Engineers Comments Regarding Surface Water Drainage

Application Reference:	CM/19/26/PL	Reviewer Reference:	ADC/EXT5/AF
Planning Officer:	Kathryn Welch	Date of Review:	24/08/2026
Site Name:	Baird Business Park Grevatt's Lane Littlehampton BN17 5RE		
Application Description:	Erection of replacement commercial building, parking and other associated infrastructure, including new attenuation pond. This application is in CIL Zone 5 (Zero Rated) as other development.		
Assessment Number:	2

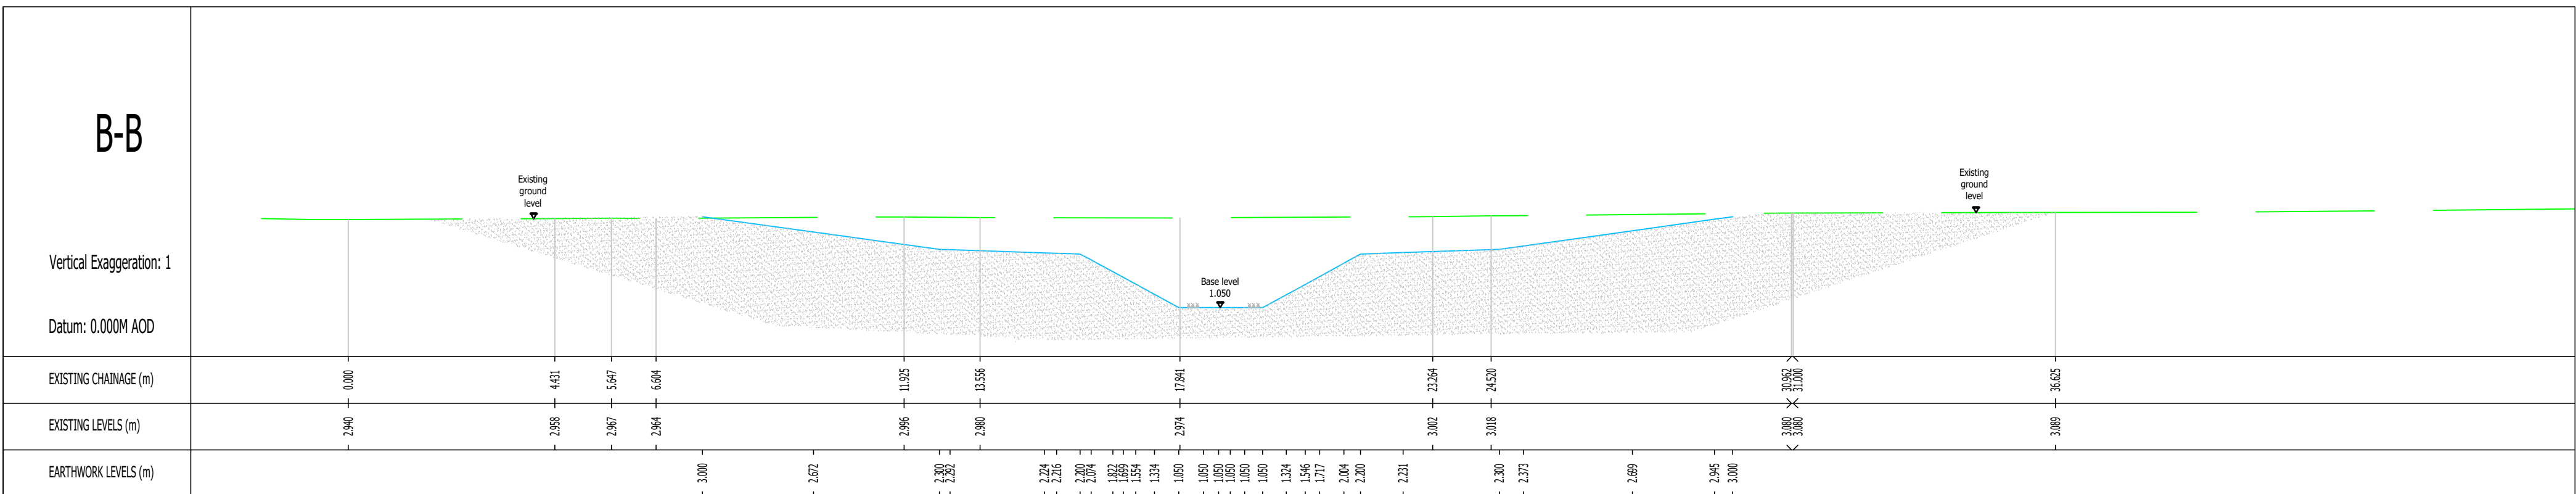
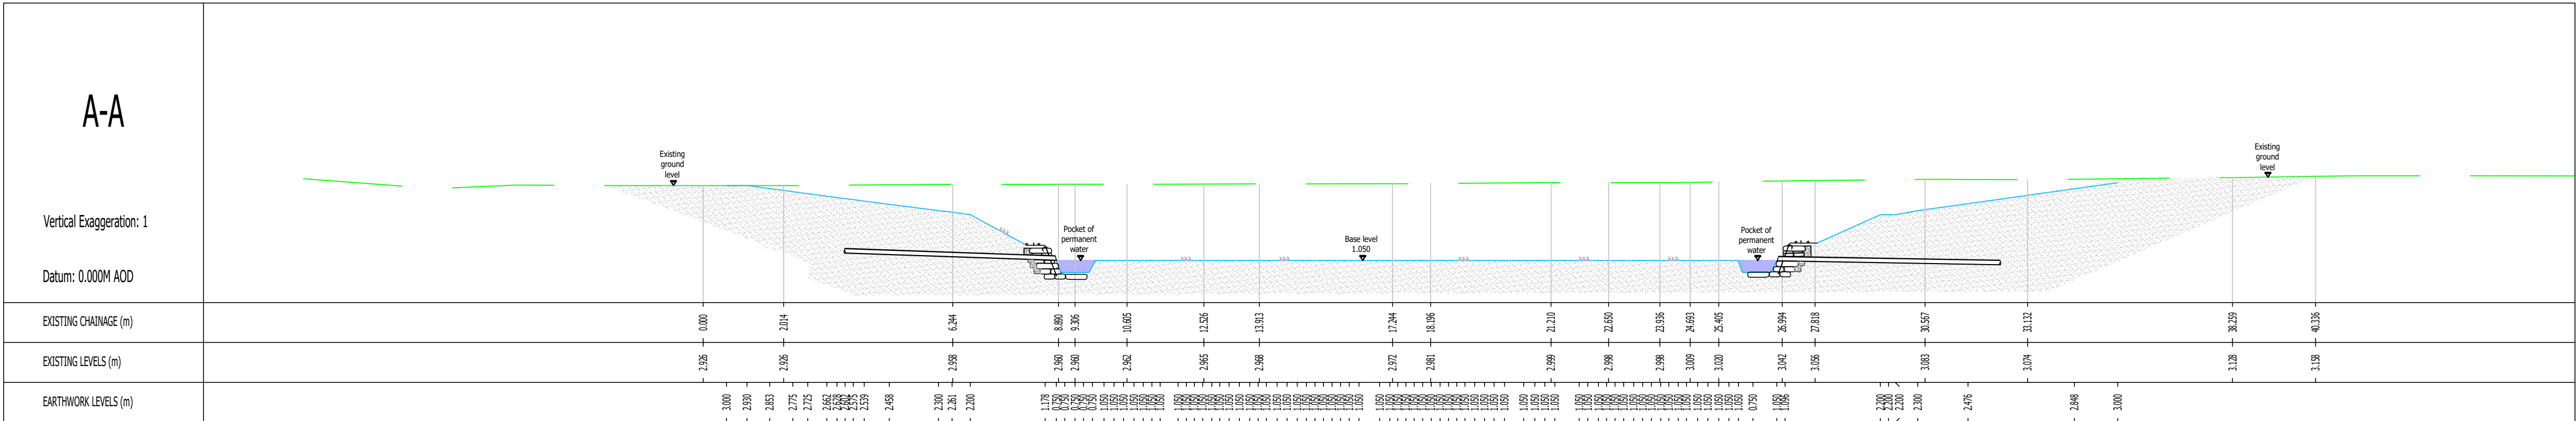
- 3.3. The proposed basin is in a location within or adjacent to surface water flood risk, and potentially fluvial flood risk. An assessment of the with climate change surface water flood risk extent should be included to demonstrate the basin is outside of the 1% AEP extent for fluvial and pluvial sources as required by the NSfS.

- 3.4. The proposed surcharged outlet basis and level is appropriate but the surcharge is not shown in the hydraulic calculations.
- 3.5. The mass balance in the hydraulic calculations is low and indicates losses which should be addressed.

Drawing Tree Constraints Plan

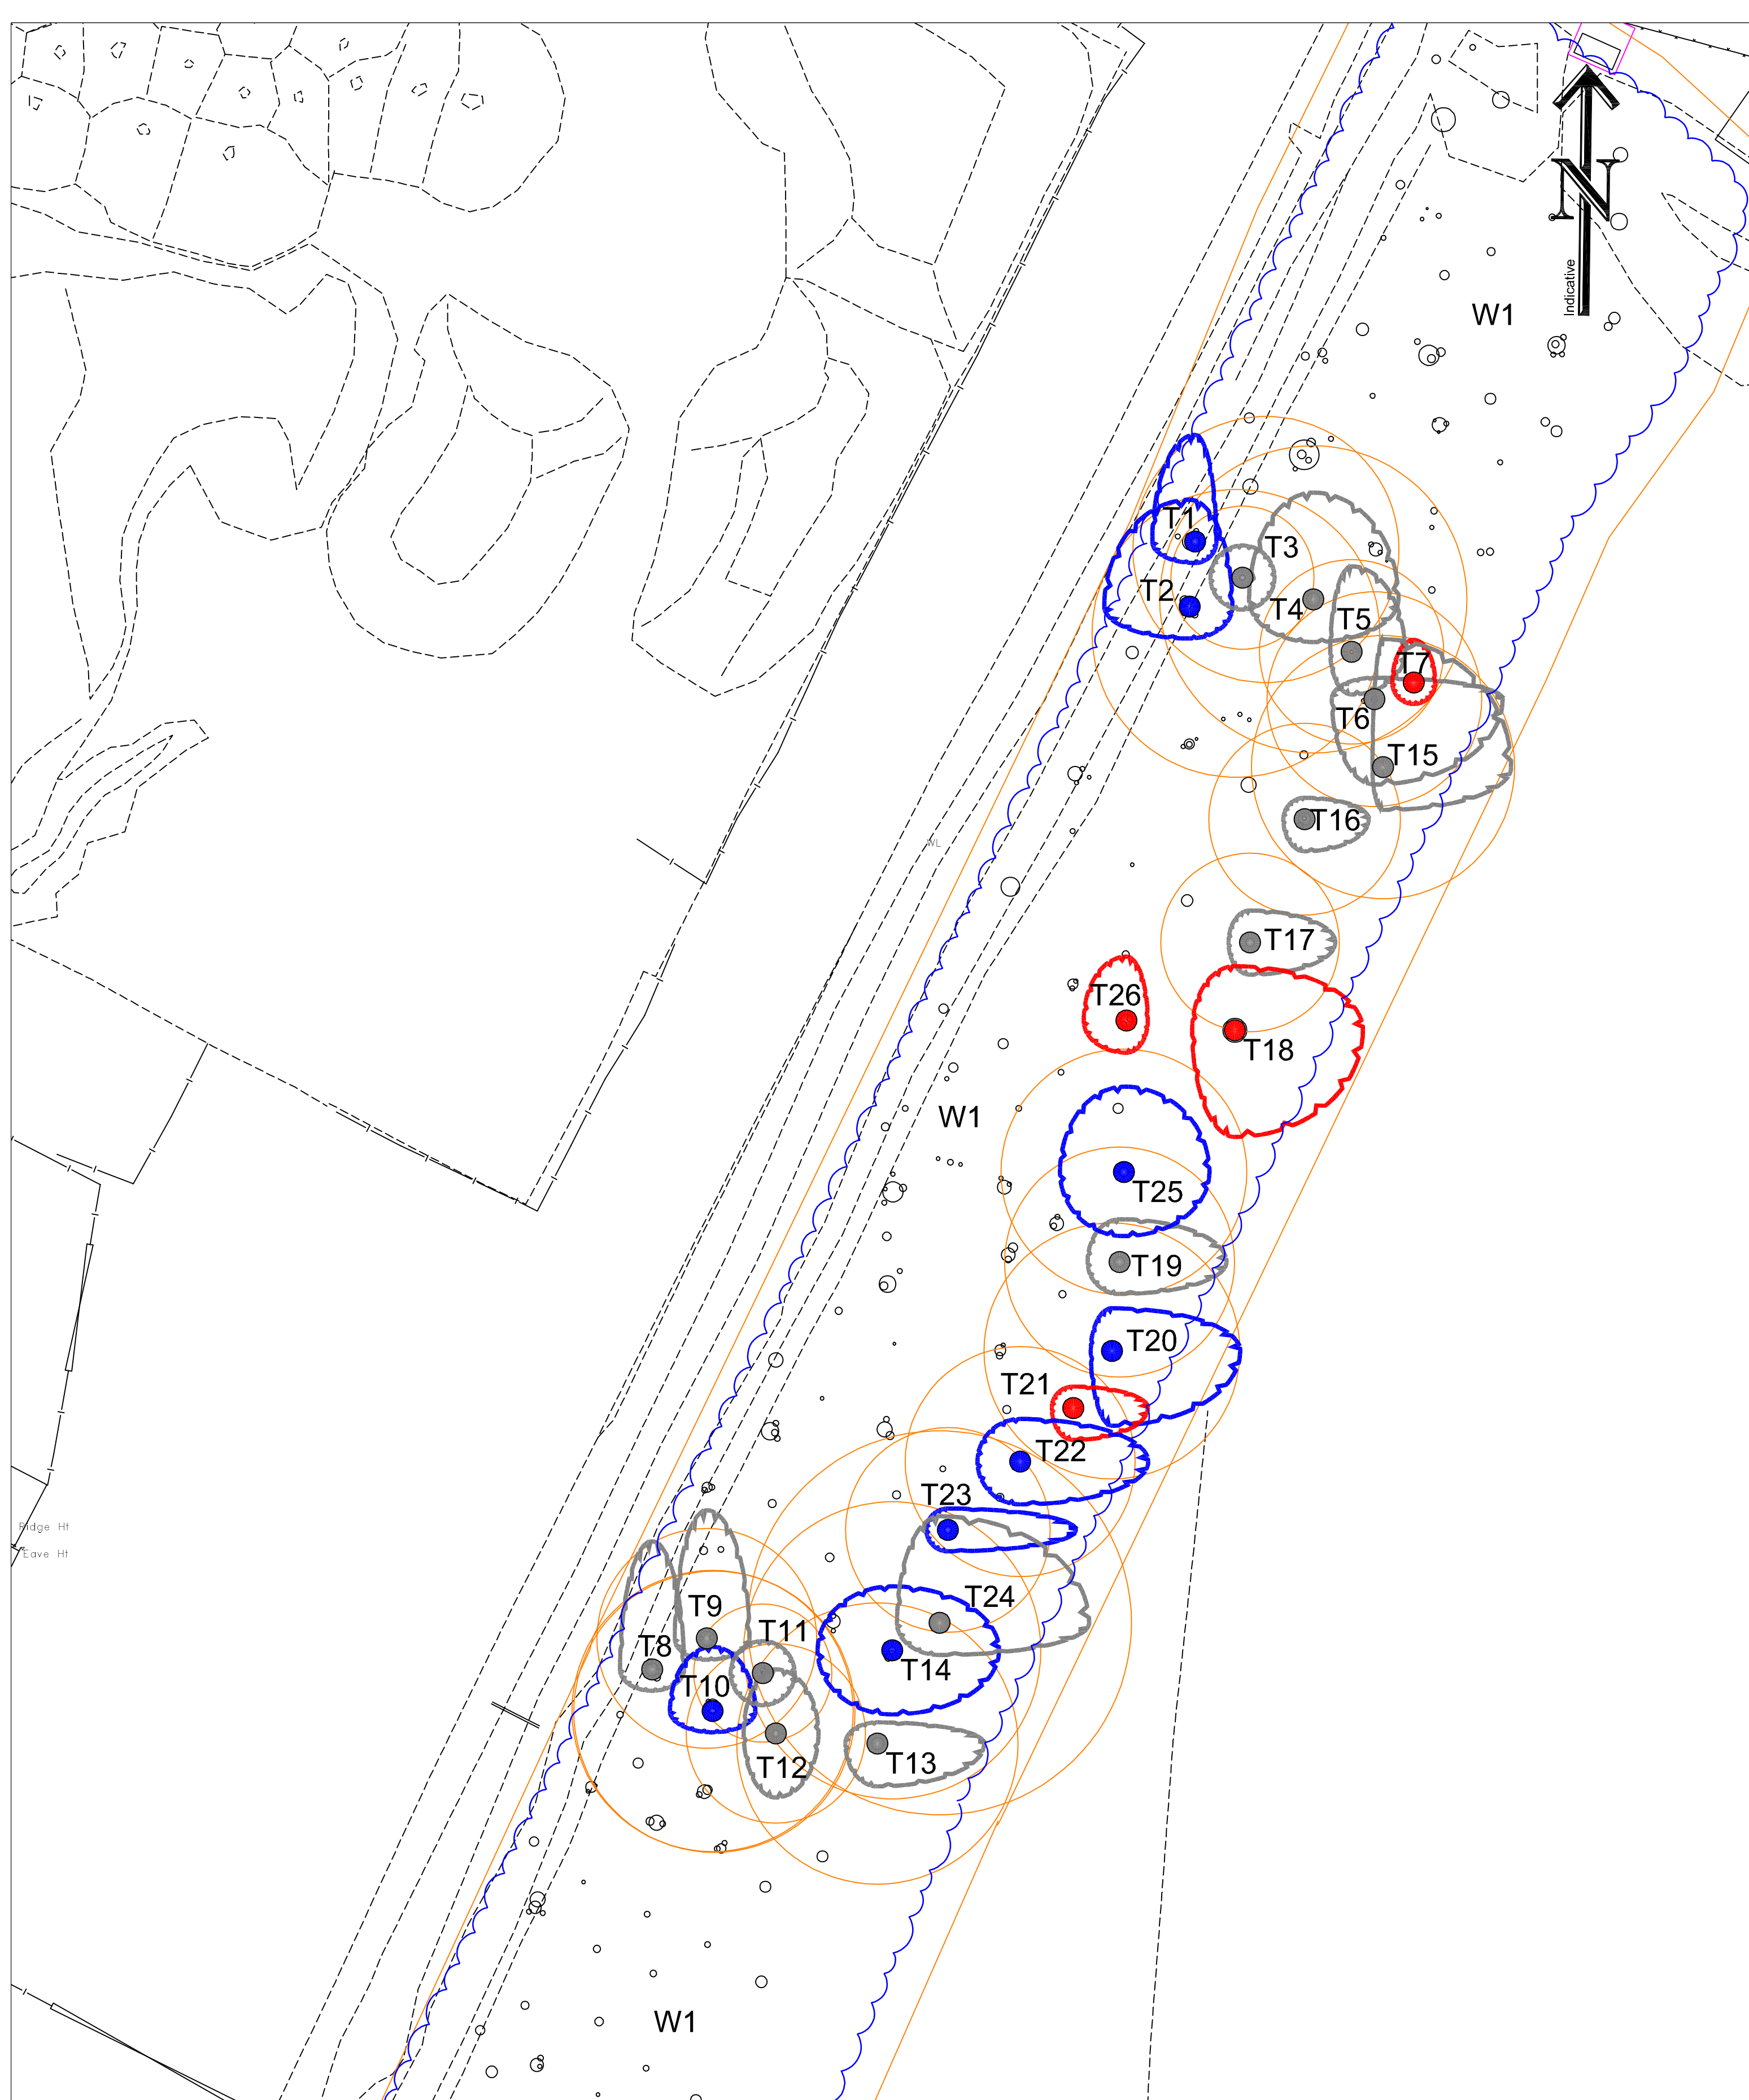
- 1.5. The runoff destination is acceptable.
- 1.6. Note – two trees are shown to be removed to facilitate the drainage route to the outfall and the tree Officer should be consulted.
